**Our Ref: FG/46/19/PL**  
**Your Ref:**

**Town & Country Planning Act 1990 (as amended)**  
**Town and Country Planning (Development Management Procedure) (England) Order 2015**  
**Application for Planning Permission**

**Development** Refurbishment of existing car park. Providing a permeable SuDS ground reinforcement grid paving system. Providing a level allocated car parking spaces.  
**Location** East Of The Bluebird Cafe South Drive Ferring

Drawing
Existing & Proposed Block Plan

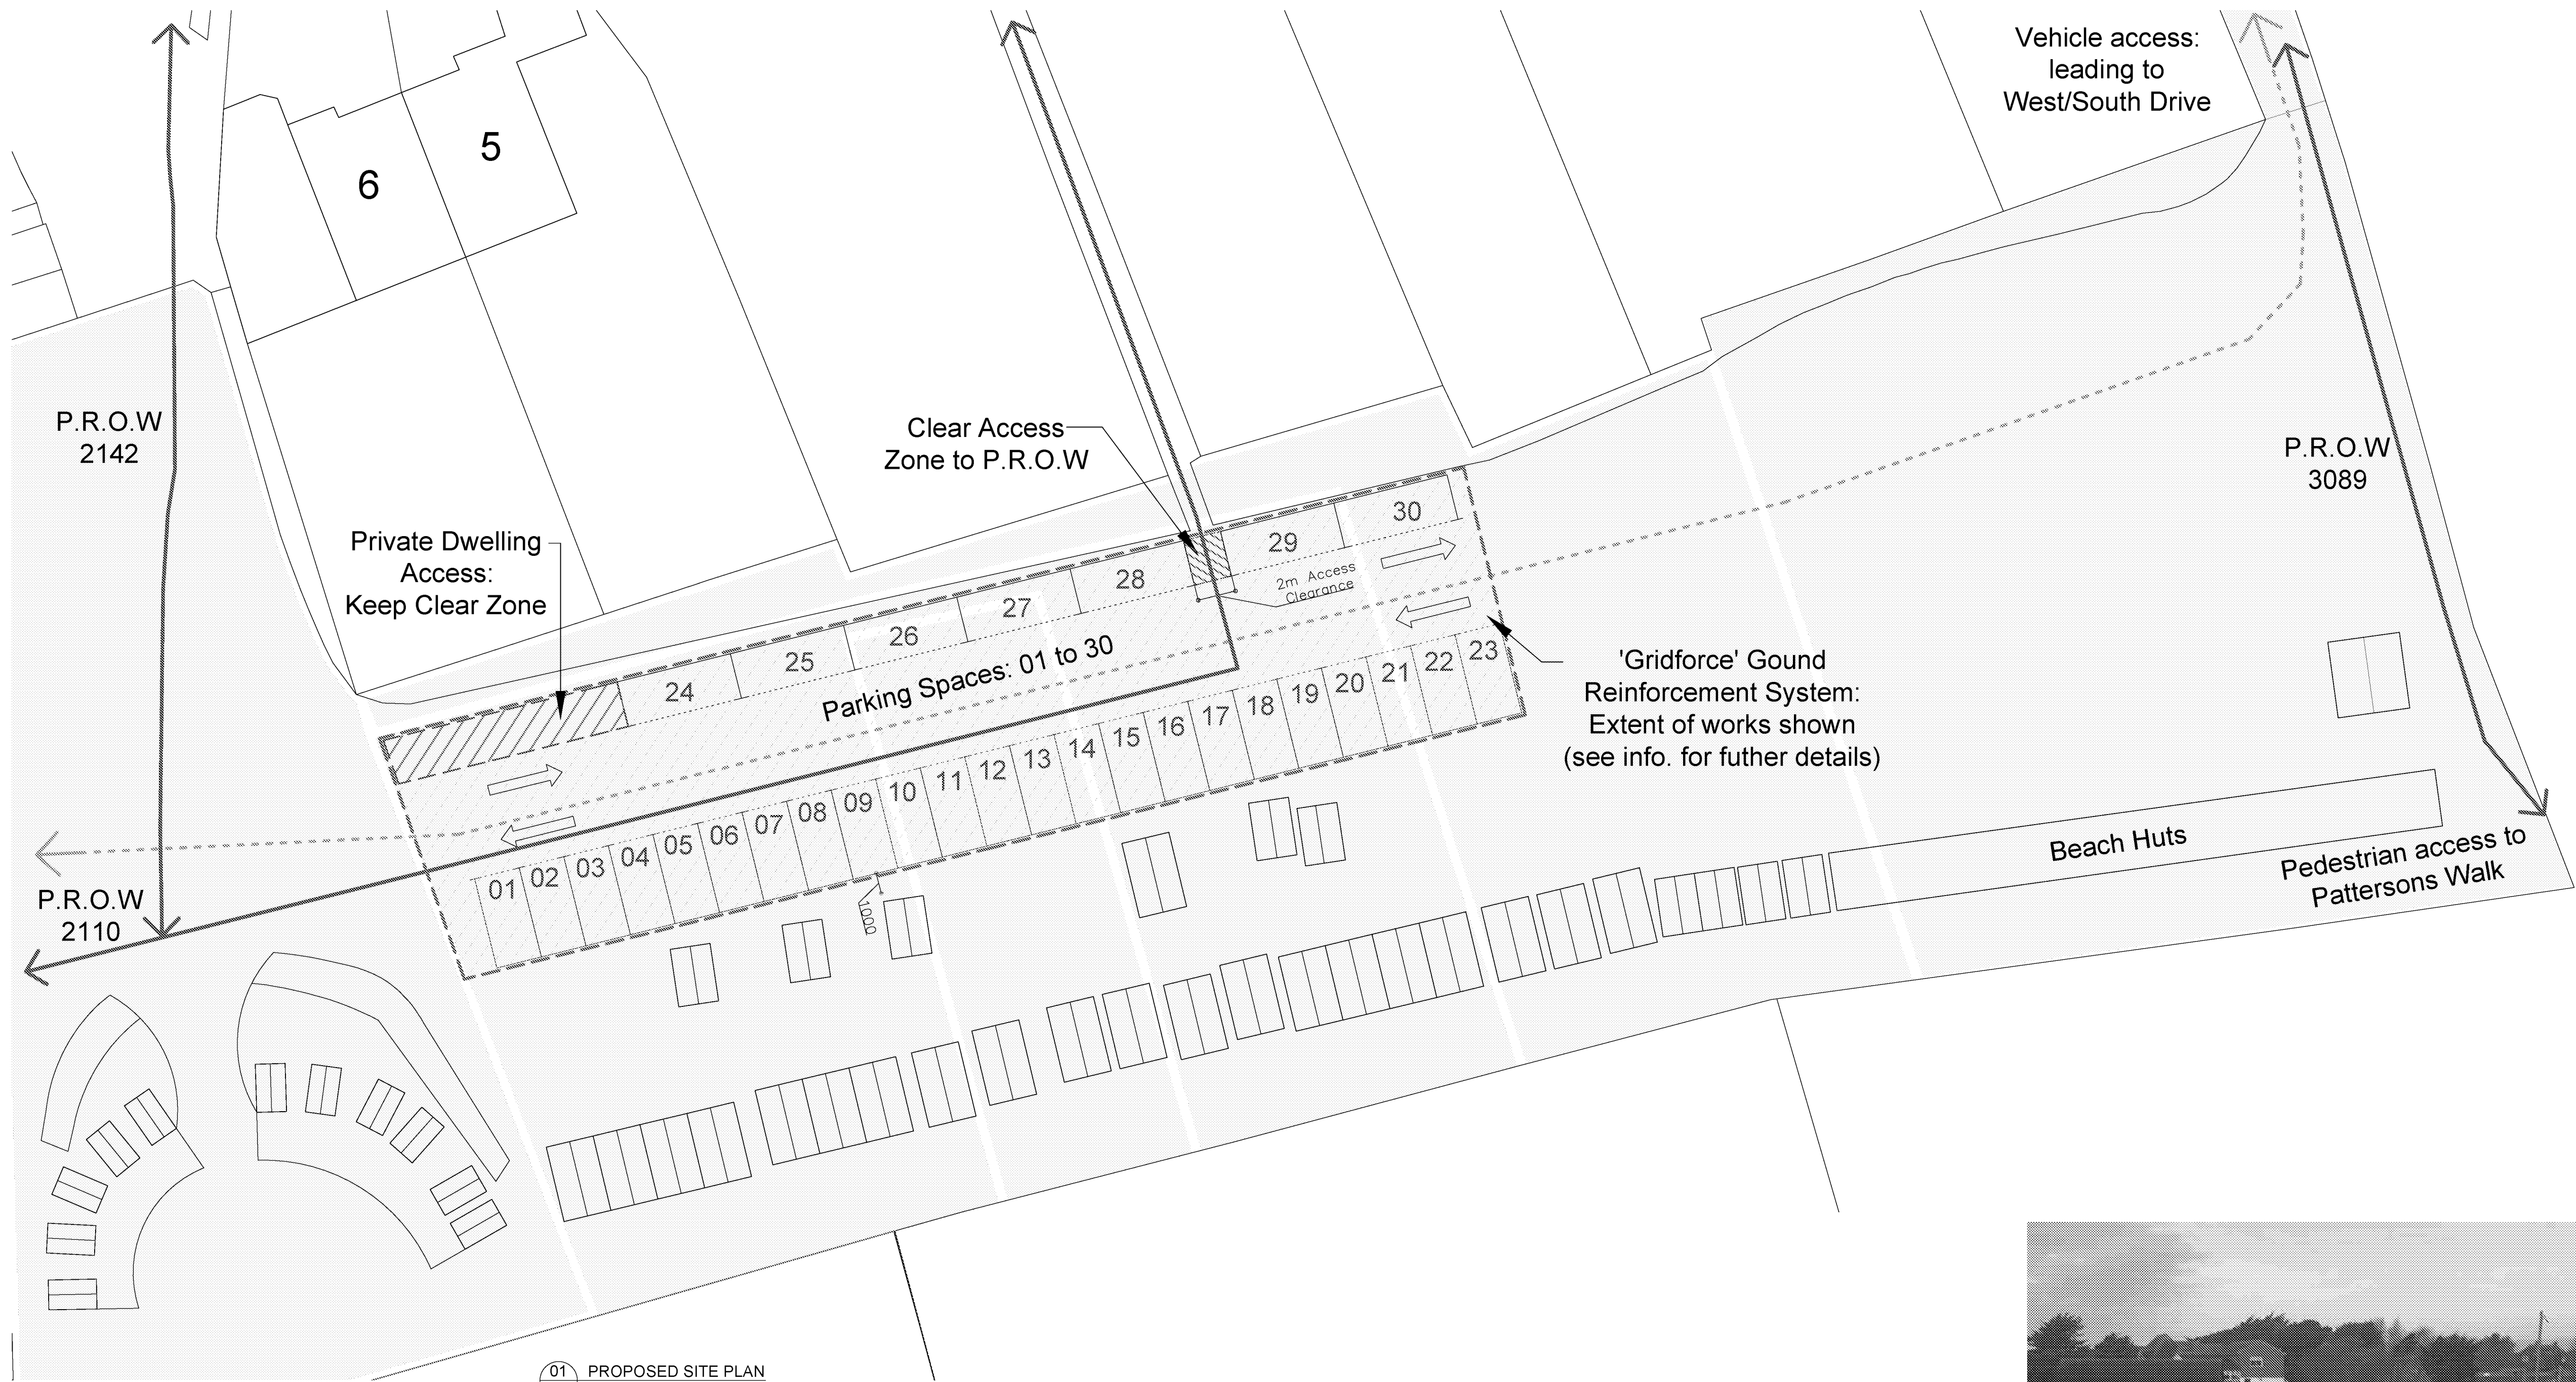
Location Plan: The red outline on the location plan does not match the block plan or our GIS. Please amend accordingly to include the whole site.
